**Consultation Response from KC,
Ecology Unit**

2026/91714 adj, 7, Quarryfields, Mirfield, WF14 0NT

Erection of detached dwelling

Responding Ref: 2608/38

Proposed Site Plan
1 : 500

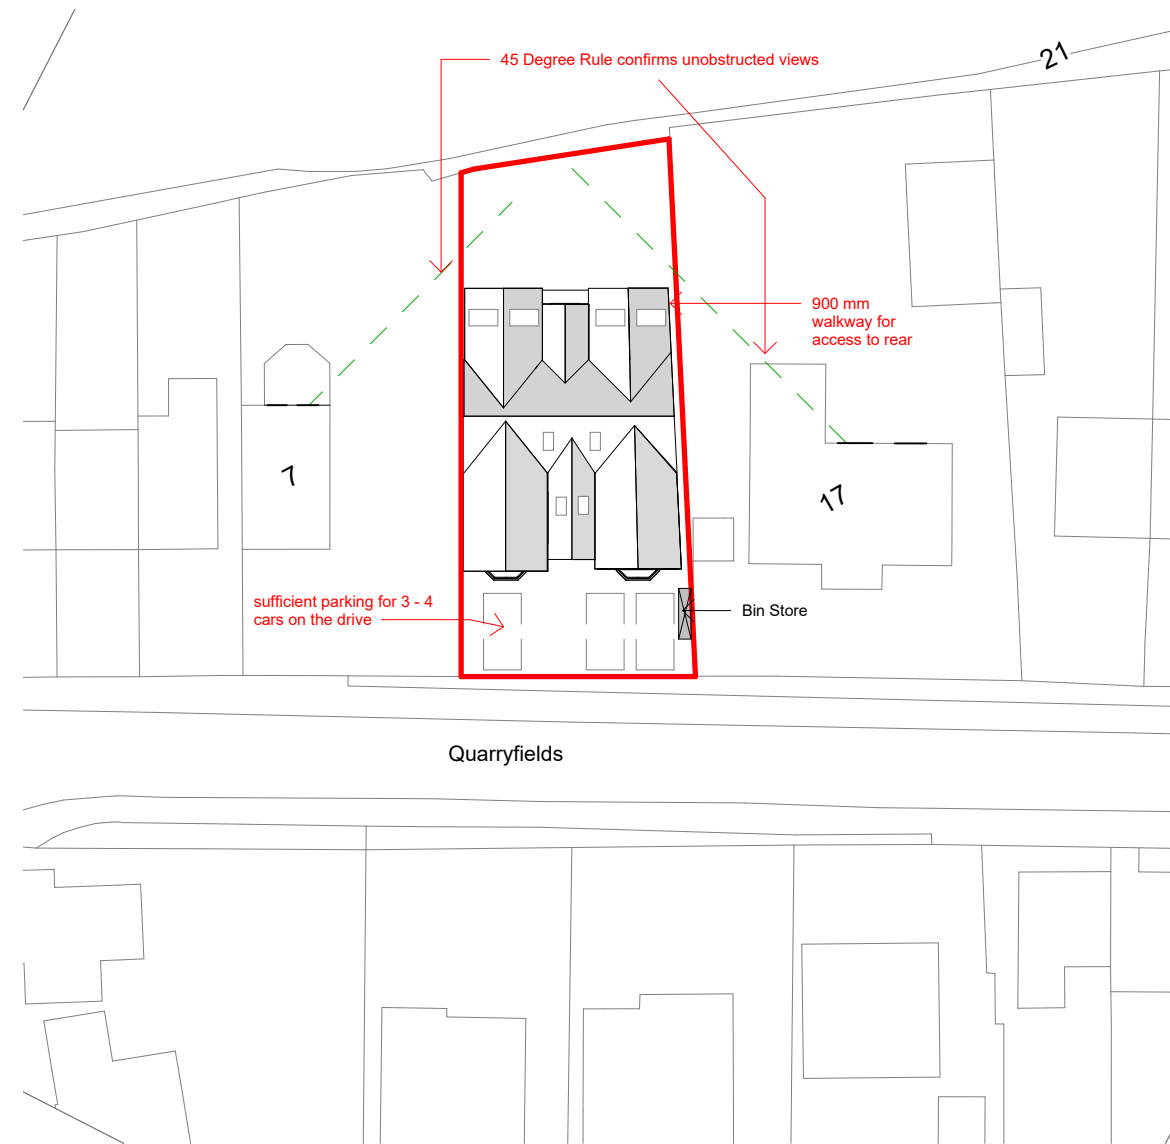
I would note that the PEA does not consider the adjacent trees or the root protection area of these. The plans appear to show the new building will be built immediately adjacent to this tree line, and potentially within the root protection area of these trees. Further assessment of the impact of the proposals on these adjacent trees, and their long-term viability, may be required. I would also recommend that further consideration on how the long-term management of these trees would be possible, as the plans show no access to the hedgerow once the building is complete.
